**REQUEST**

Current Zoning: R-3 (single family residential)  
Proposed Zoning: MX-3 (mixed use) and UR-2(CD) (urban residential, conditional)

Approximately 240.32 acres located on the west side of Steele Creek Rd, south of Sledge Rd, east of Shopton Rd

The petition proposes the development of a mixture of up to 550 single family attached and detached homes and 150 continuing care/retirement community units.

Technical Data Sheet - Continued  
(Sheet 3 of 4)  
Petition # 2019-128  
**GAMBRELL SITE**  
City of Charlotte, NC & Mecklenburg County, NC  
Pulte Group

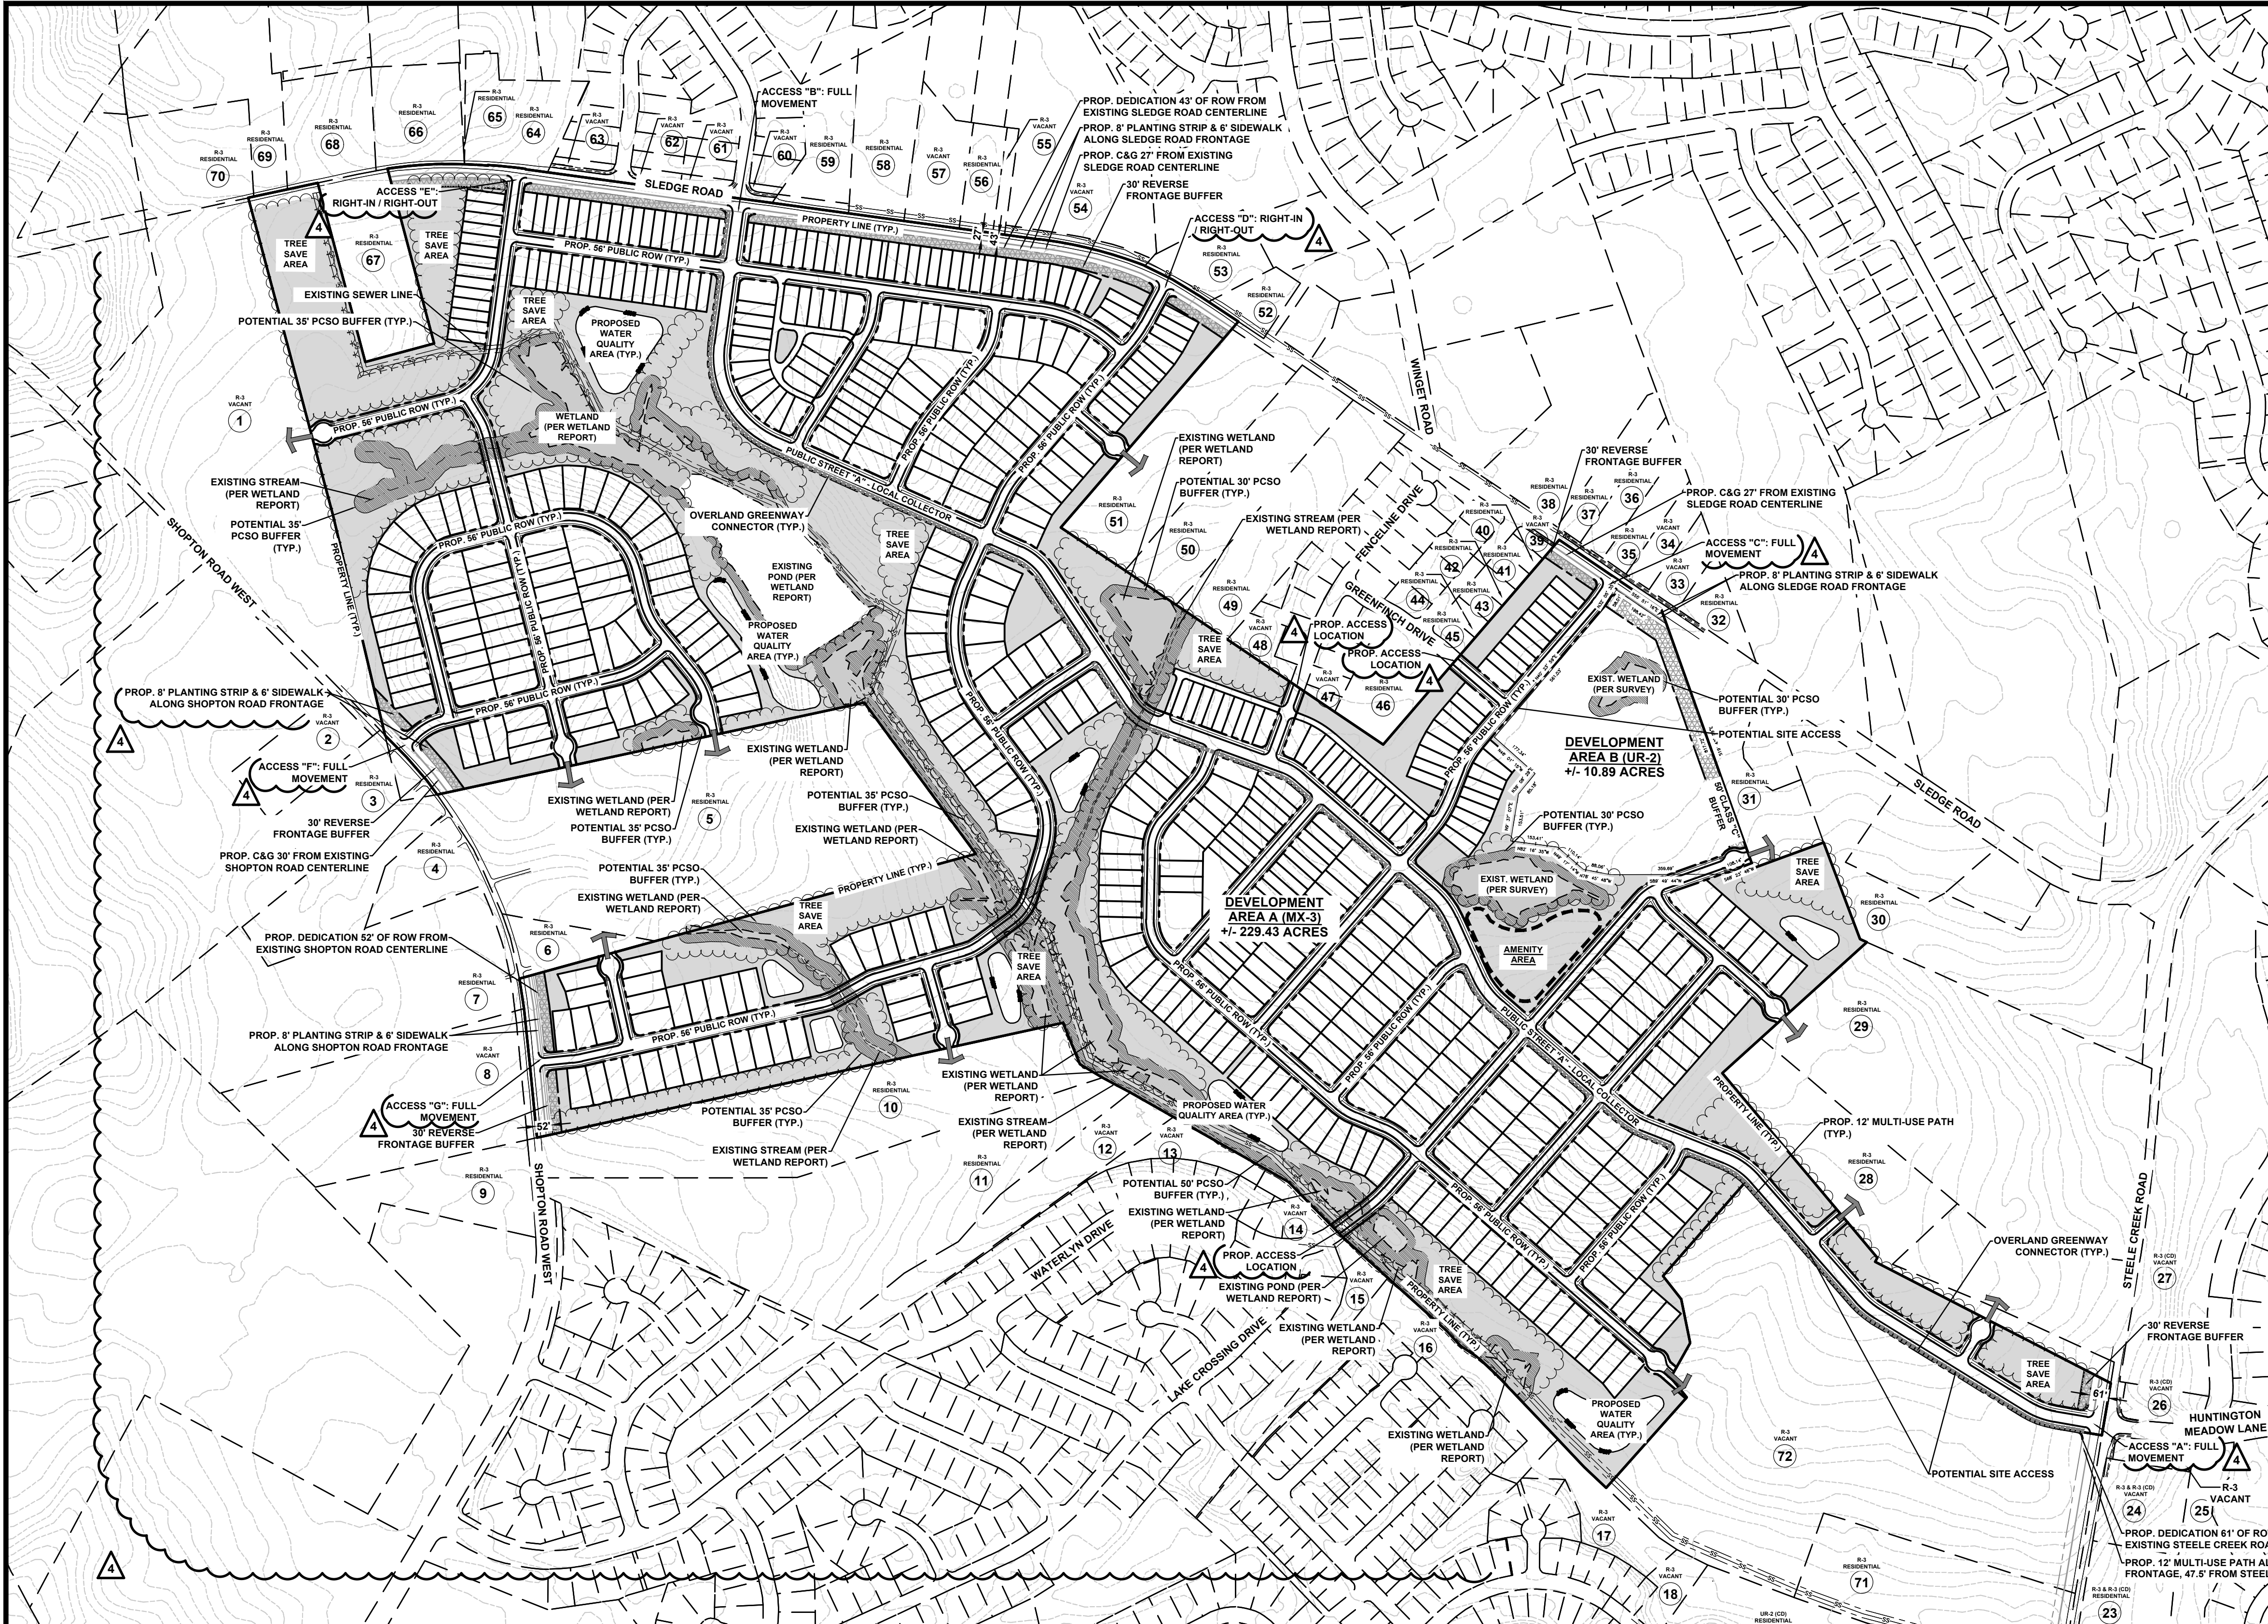
- ~~1. **Curbline** The proposed zoning district has a setback measured from back of the existing or proposed future curbline. Label and dimension the curb lines from the centerline.~~

- ~~2. Dimension the right-of-way from the centerline. Please show this dedication in front at Access L. All rights-of-way, curb lines, planting strips, and sidewalks/MUPs need to be labeled and dimensioned on **all frontages/access locations**. Typ: **ADDRESSED**~~

- ~~3. The petitioner should revise the site plan and conditional note(s) to commit to construct a 6-foot sidewalk along of the frontage of Shopton Road and to establish a connection to the existing sidewalk stub provided by the existing Waterlyn Subdivision. The site plan should label and dimension both items from the back of curb and gutter and road centerline. **ADDRESSED**~~

- ~~5. The petitioner should revise the site plan and conditional note(s) to incorporate a proposed mini-roundabout on proposed Public Street "A." **ADDRESSED**~~

- ~~6. The petitioner should revise the site plan and conditional note(s) to establish a street connection to "Development Area C." **ADDRESSED**~~
- ~~7. "Development Area C" was removed and/or not labeled, however, access was provided. Please clarify. **ADDRESSED**~~
